SITE DRAINAGE ON LAND AT THE END OF KEMPLE VIEW

Please proceed with you application we are satisfied with your proposal for the diversion of the drain.

Highway Development Control

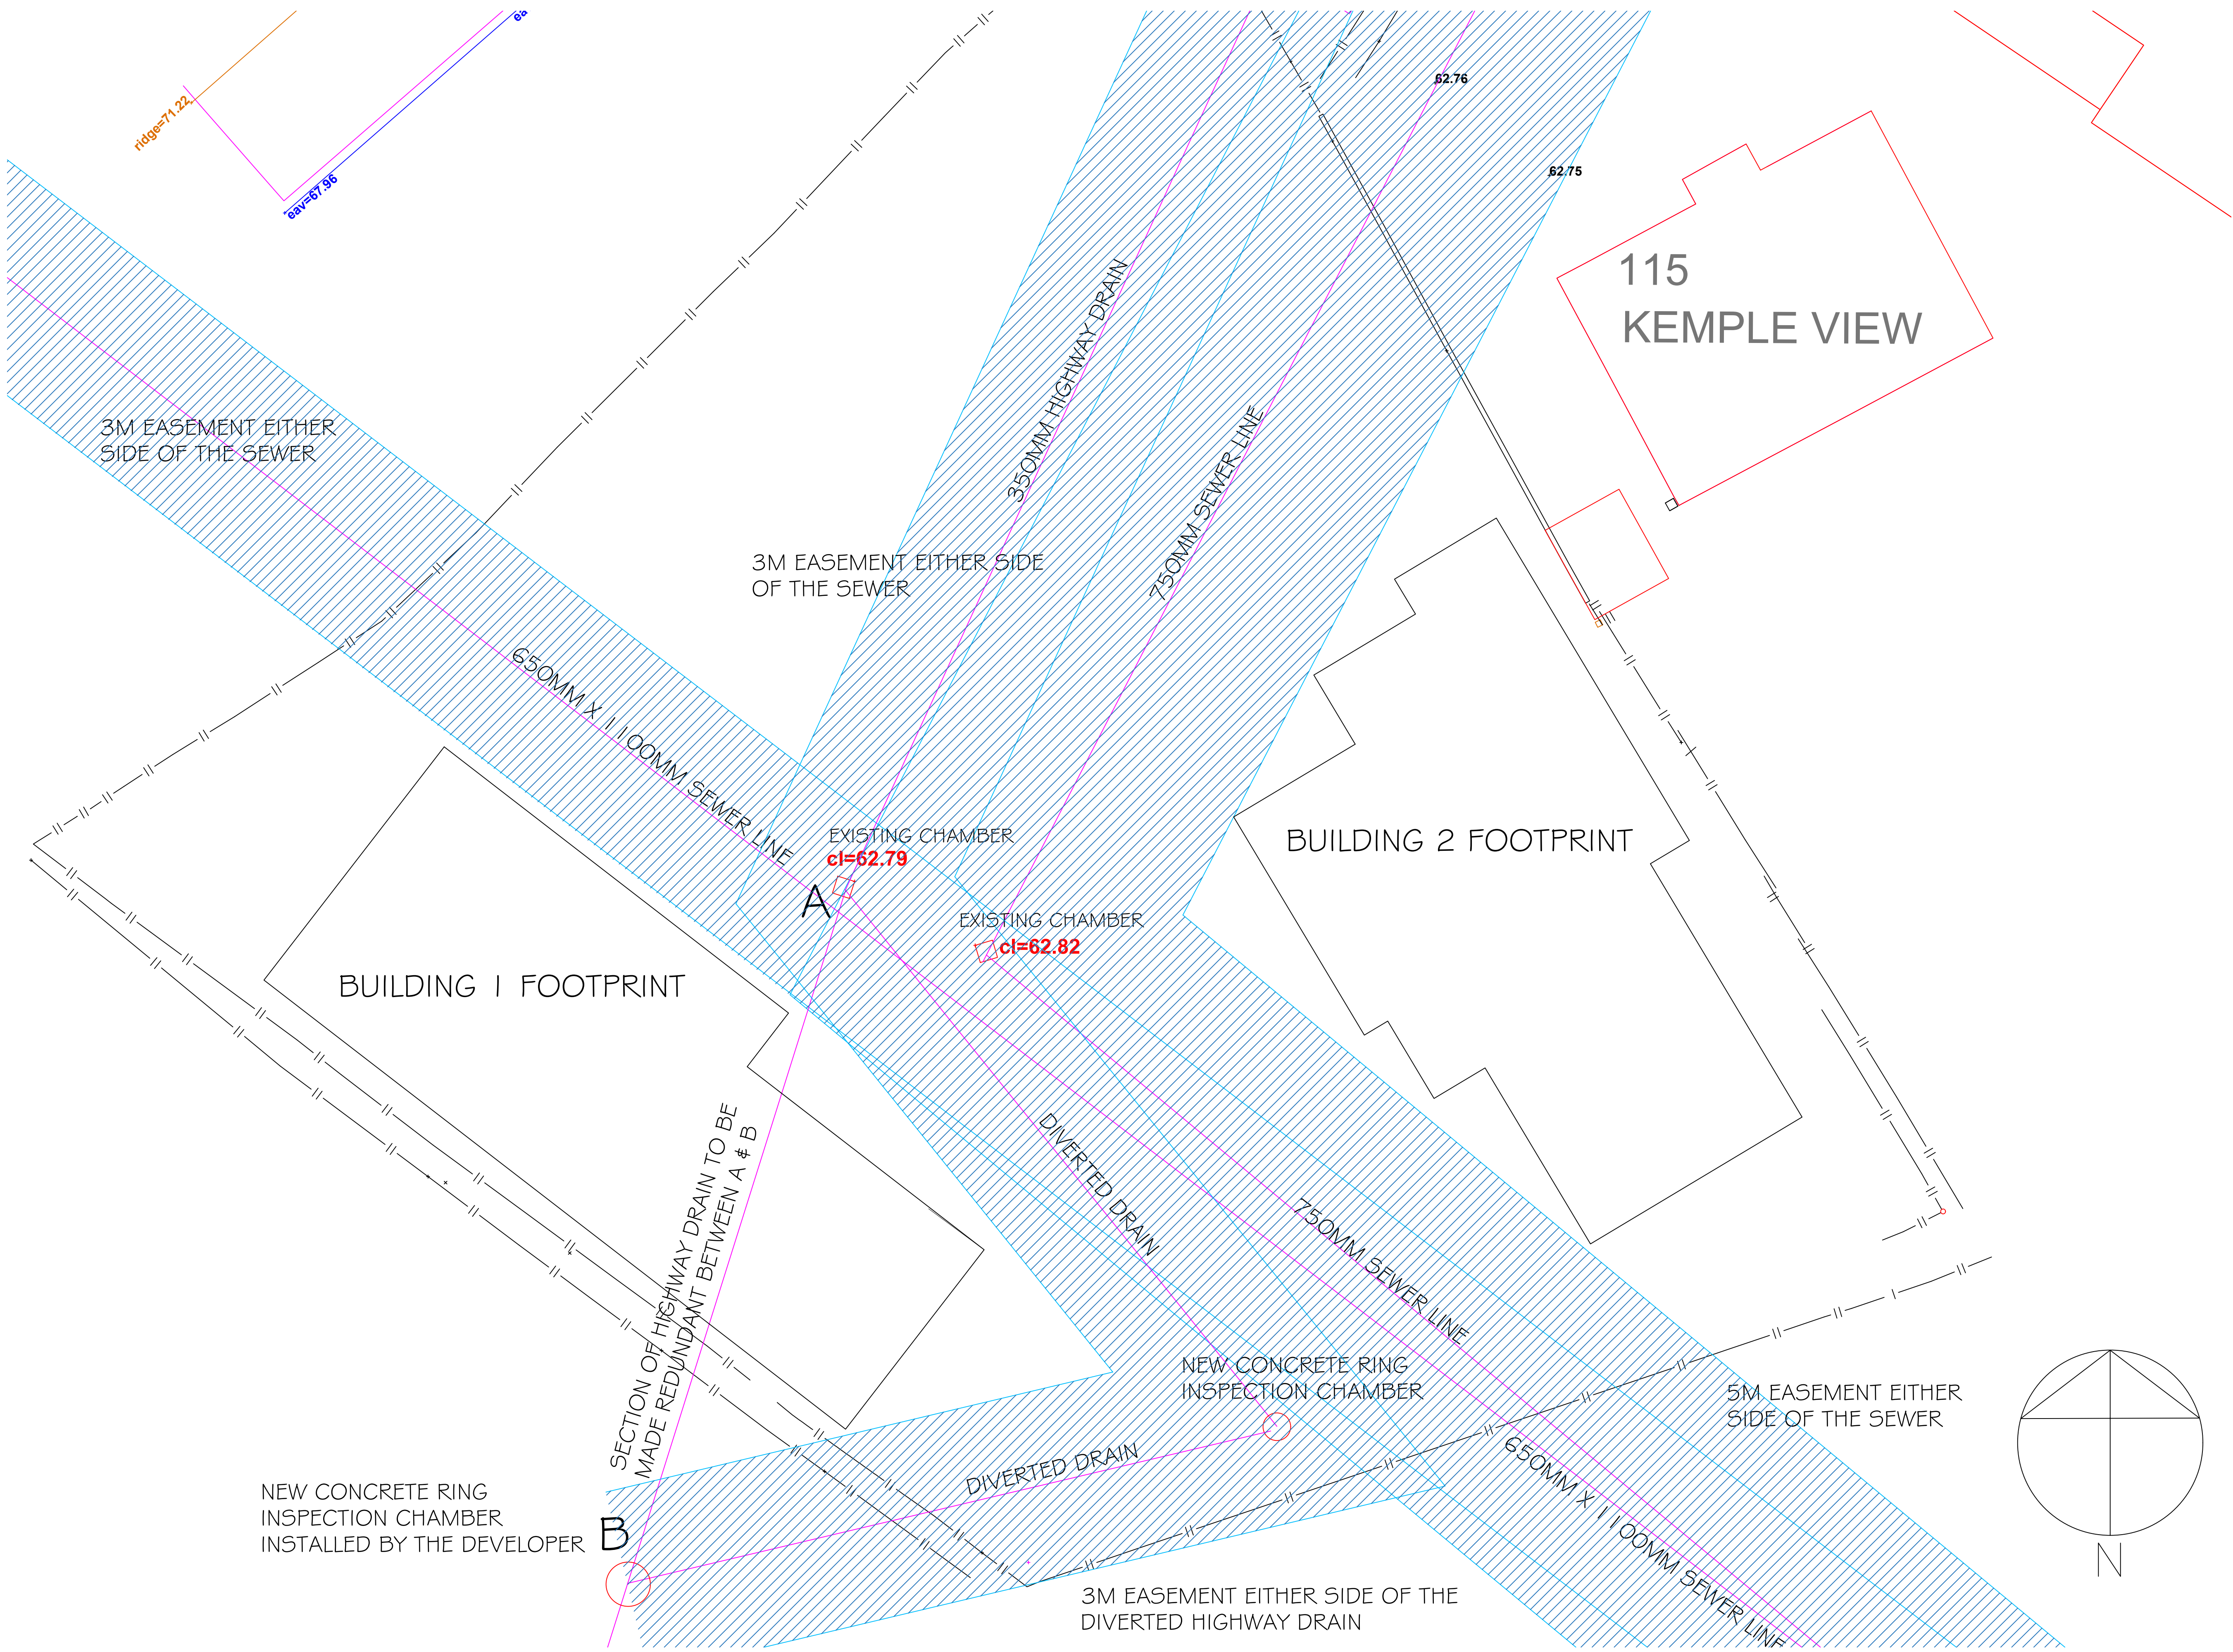
a revised plan which demonstrates the potential to divert the highway drain around

house plot 2 as shown.

We have based the plan on the basis that there will be a connection point on the southern boundary following the installation of a concrete ring chamber on the adjoining land as discussed.

Our client will be installing a new compliant chamber on their land as shown and the drain line will have a 3m easement either side.

The excavations will need to be carried out in strict accordance with your requirements and we are aware that the diverted drain is close to an existing UU drain position.

Please can you advise how we carry out site excavations in close proximity to UU pipes.
